**Re: PCD File No. PPR2329  
The Rock Commerce Center, 2nd Review  
Response to Comments**

Please accept this letter on behalf of Central Development, LLC, the applicant for The Rock Commerce Center. We received your comment letter dated December 8, 2023, regarding the application and we offer the following responses:

THE ROCK COMMERCE CENTER
SITE DEVELOPMENT PLAN
GRADING PLAN

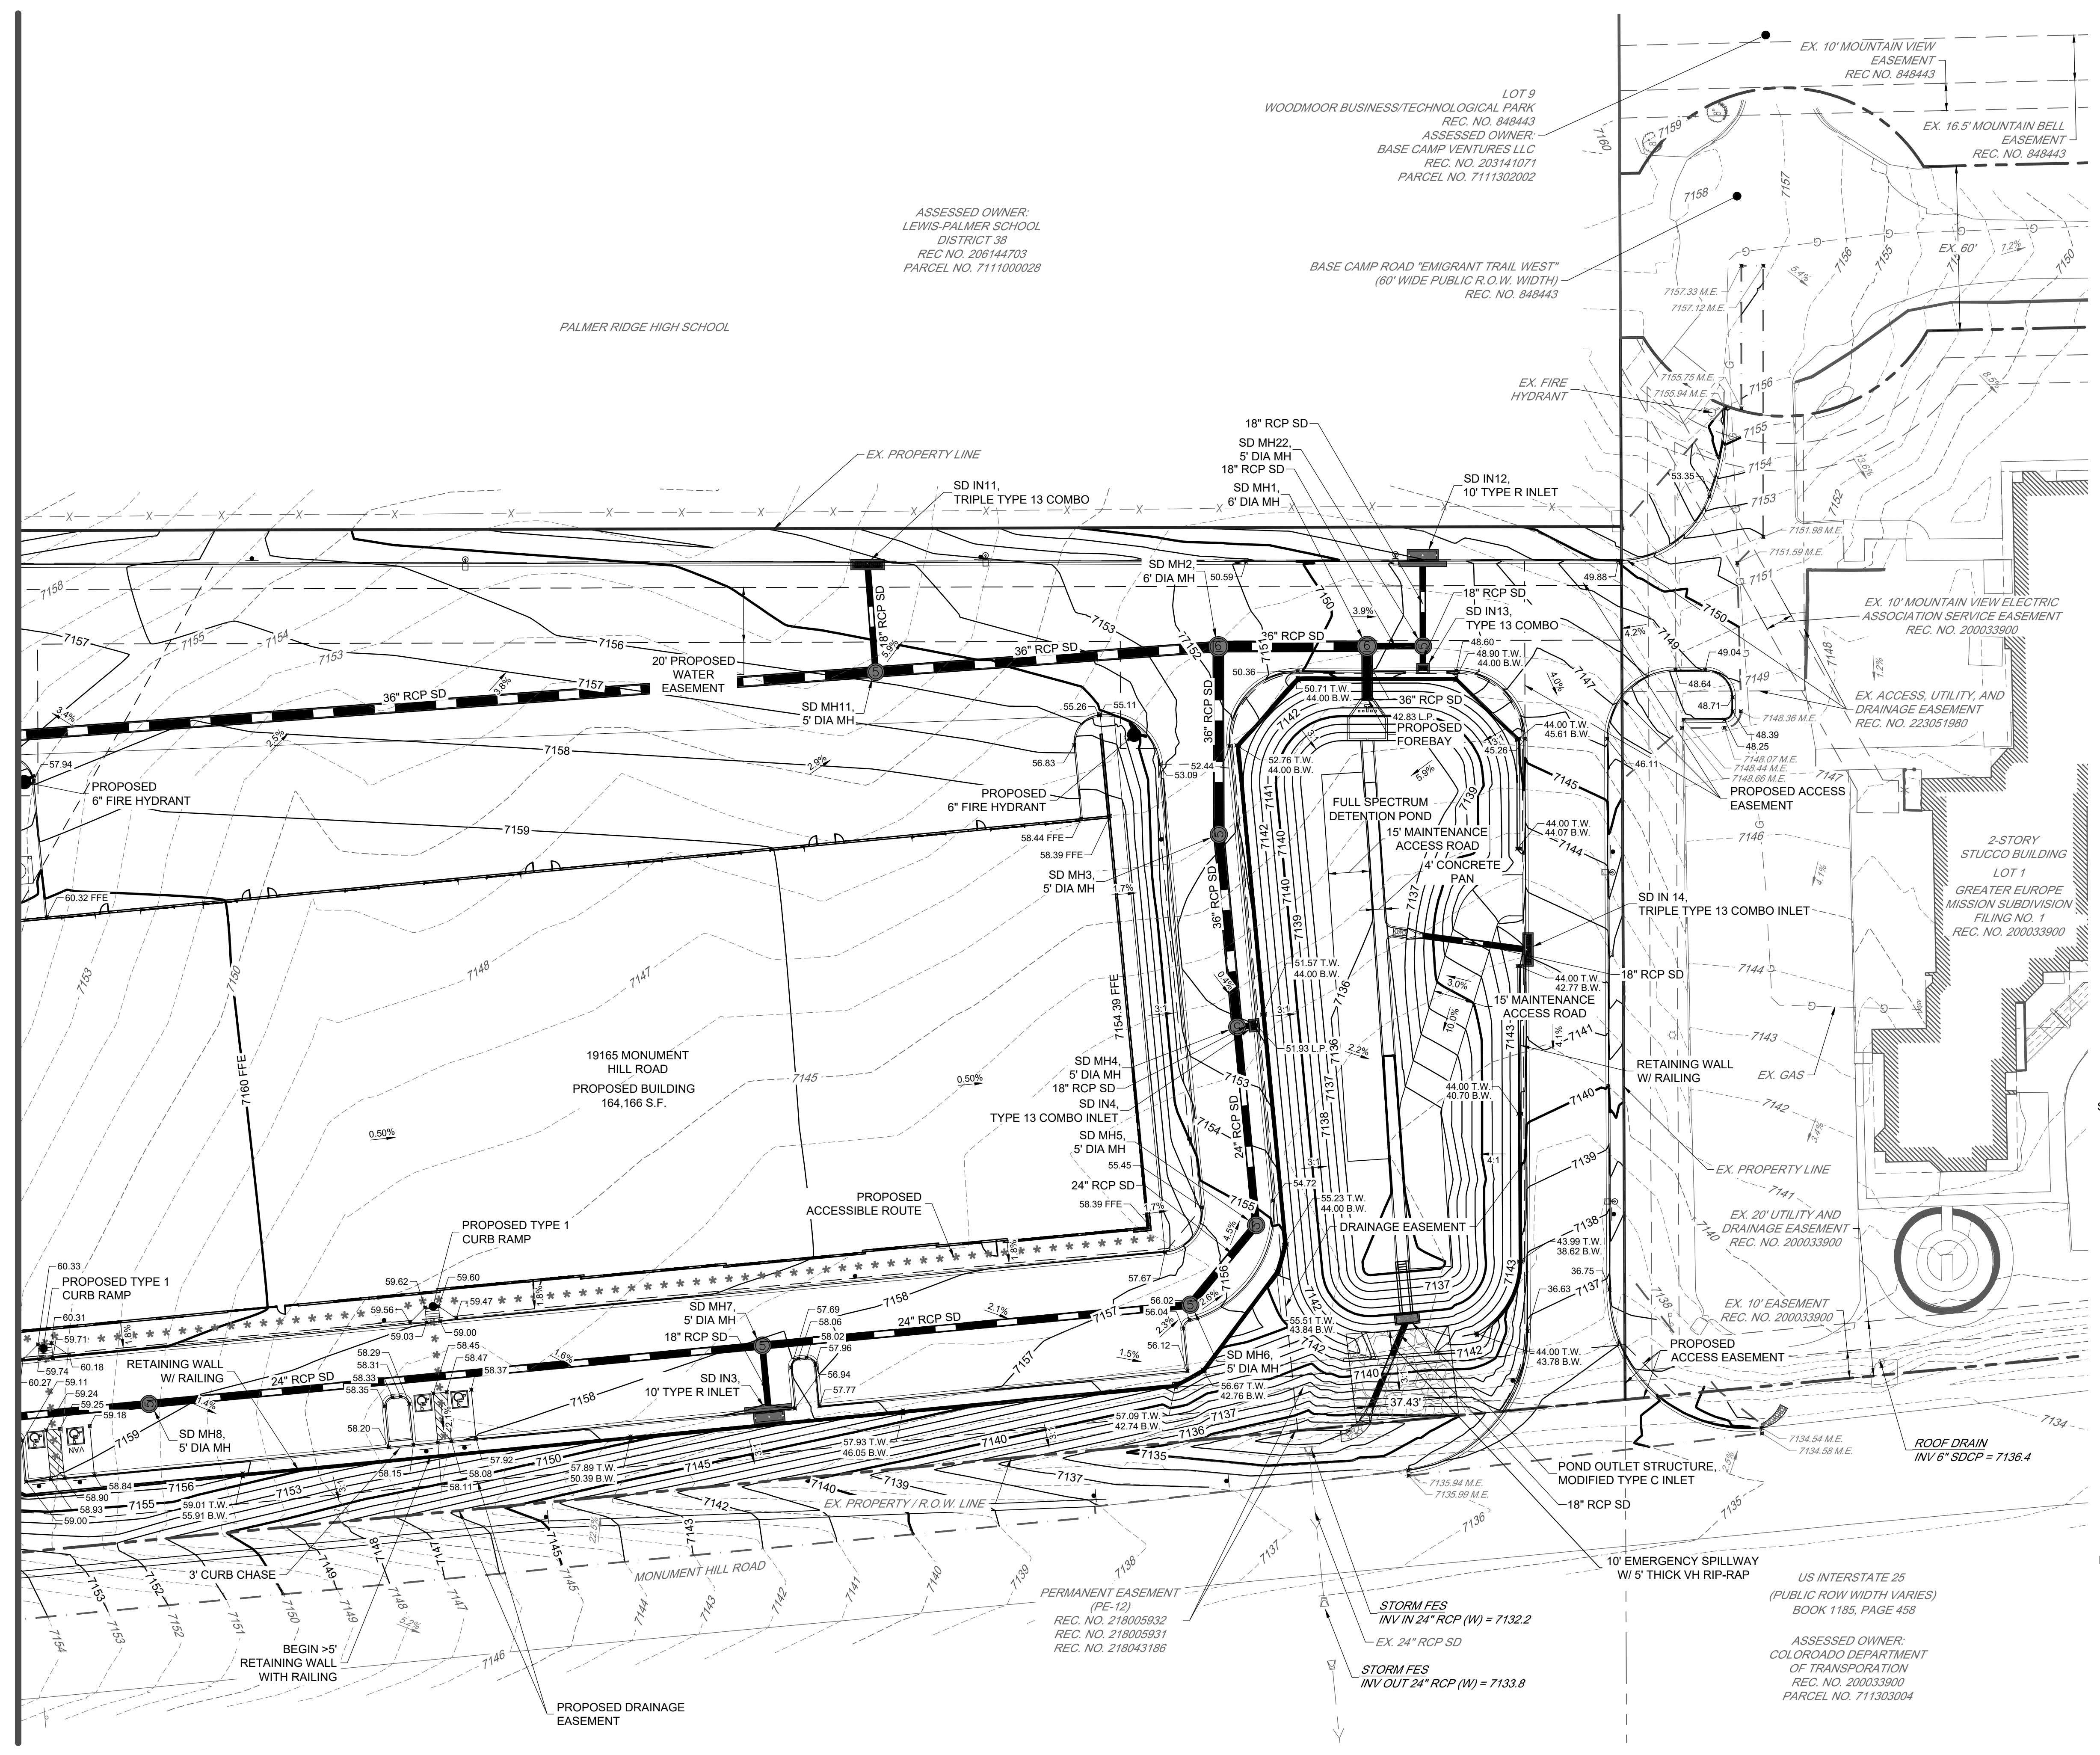
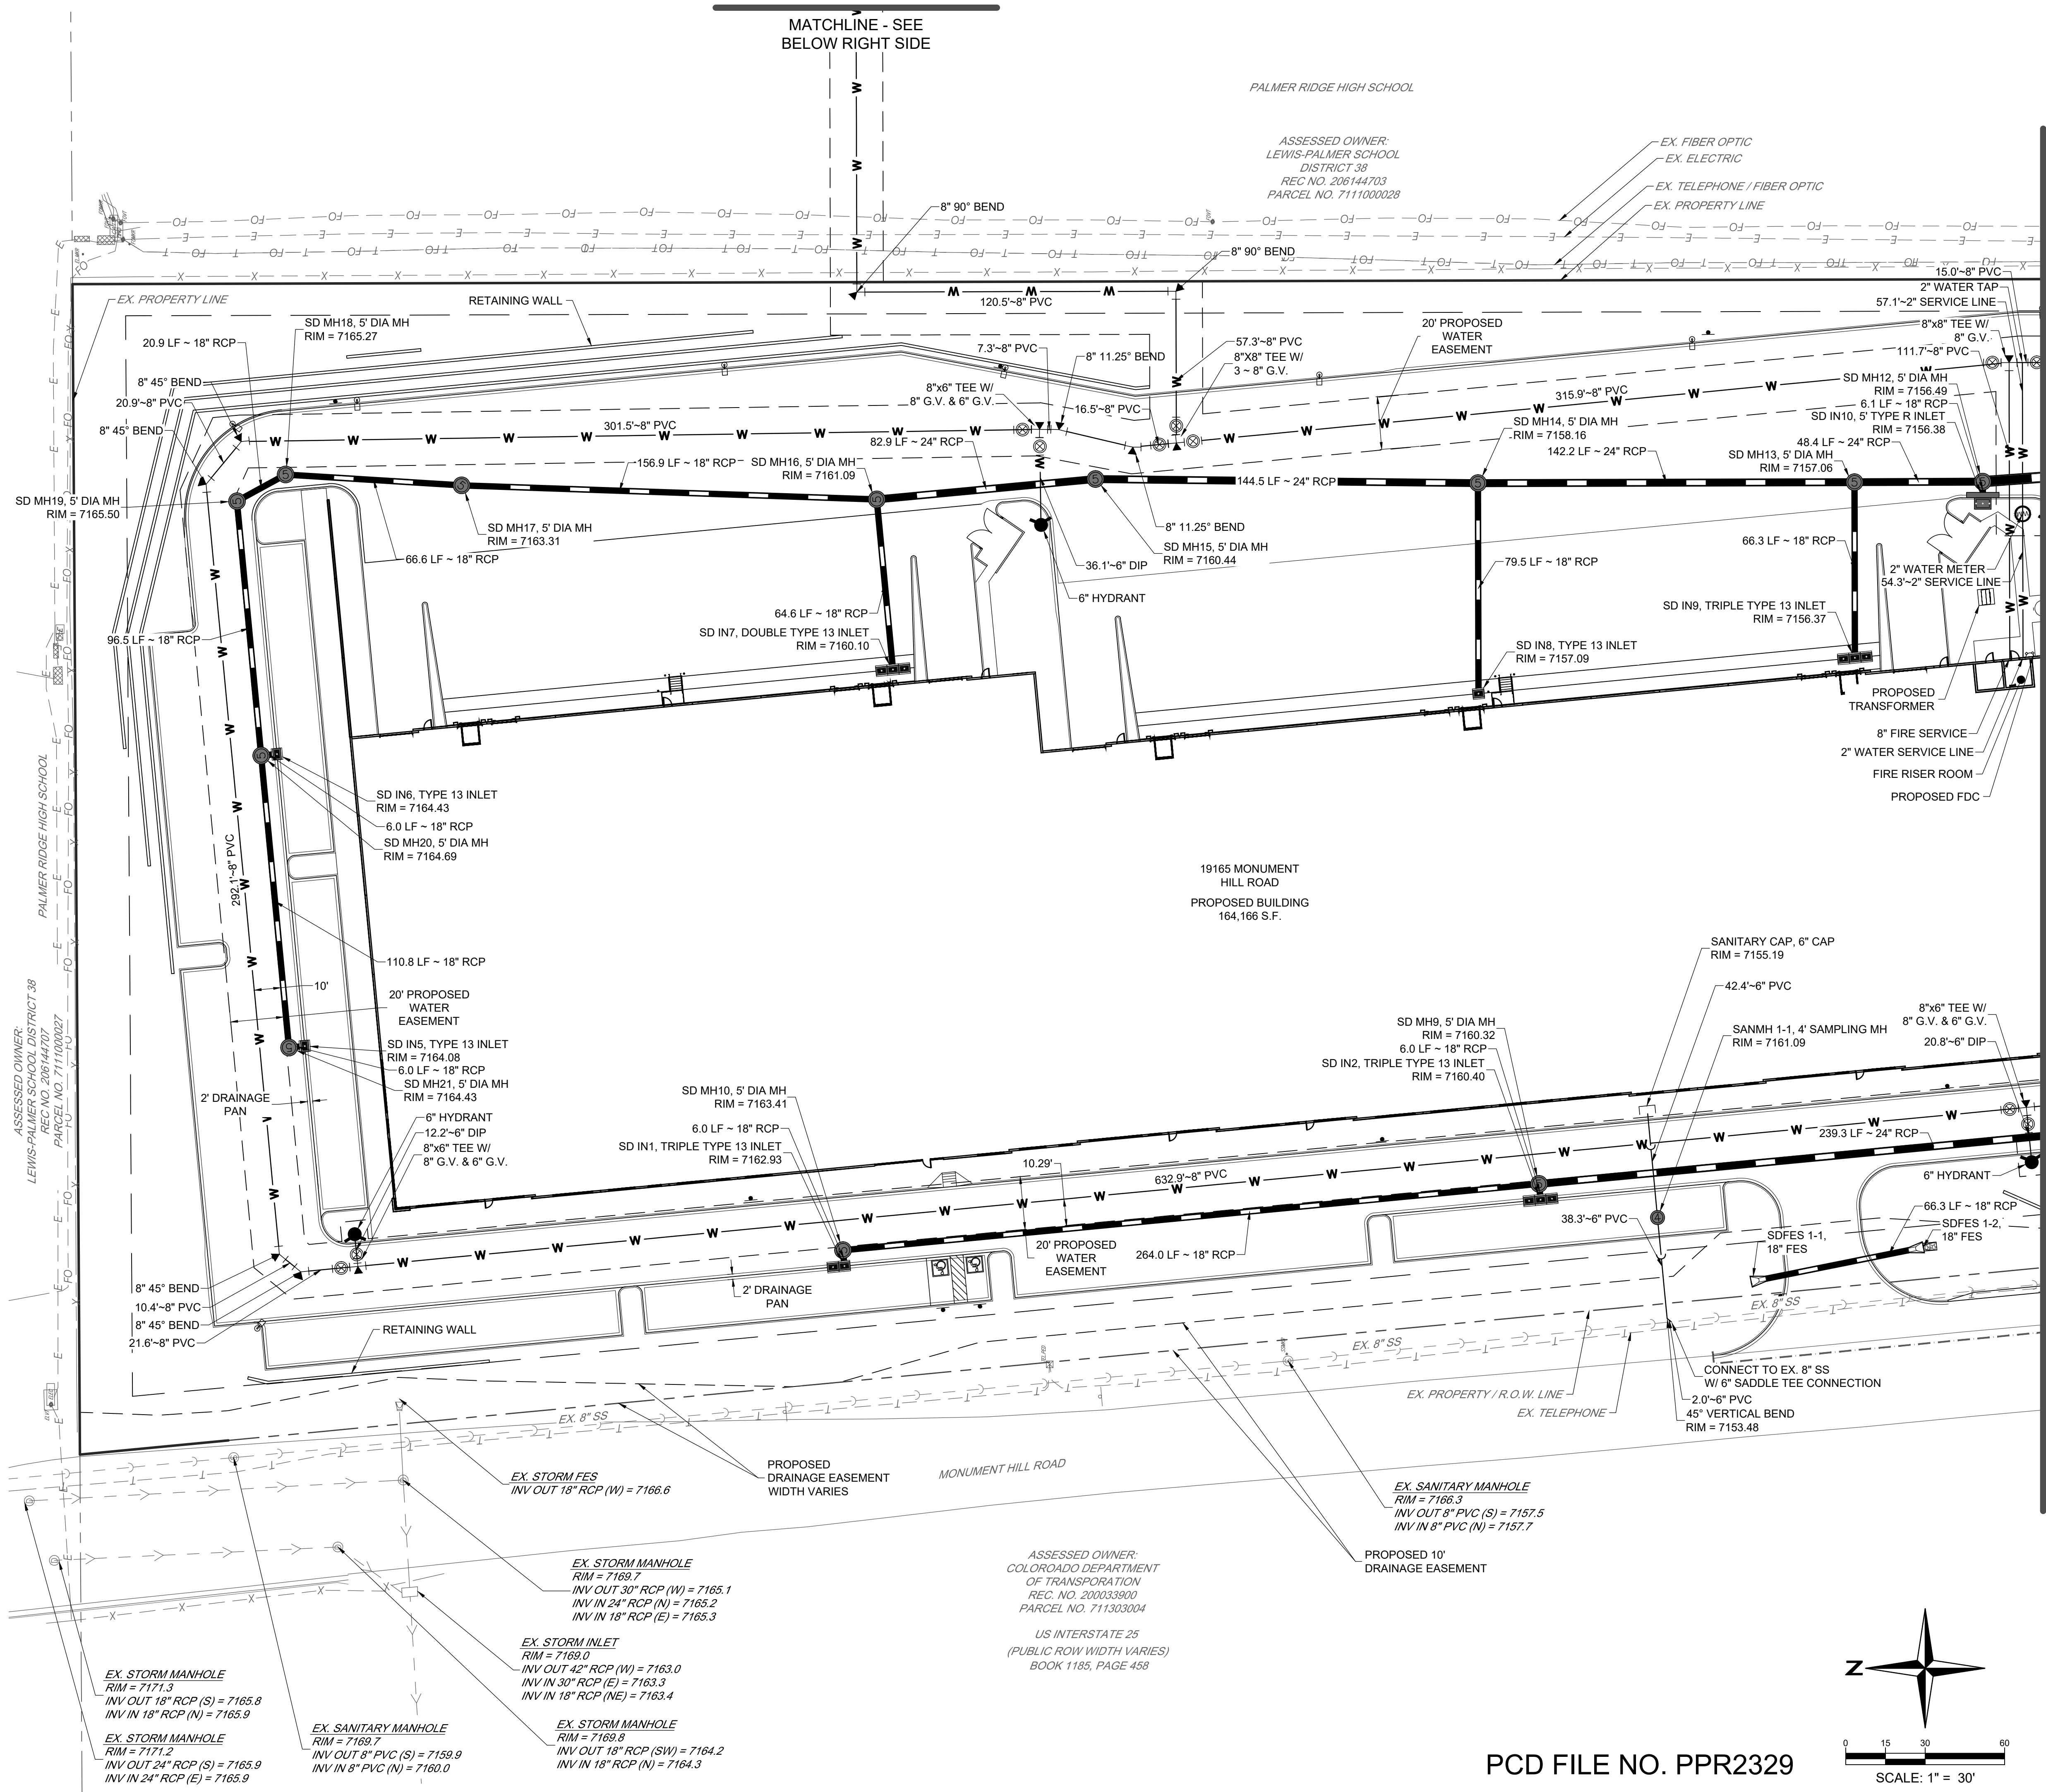
1. Wall will need drainage pan to direct flows around and not over wall. Refer to County detail SD\_3-44. Provide calculation for sizing of ditch section in drainage report.

**Response:** A drainage pan was added to direct flows around the walls and the County detail was added to the SDP set. An SF table and flow calculations were added to the Drainage Report for sizing of the drainage pan.
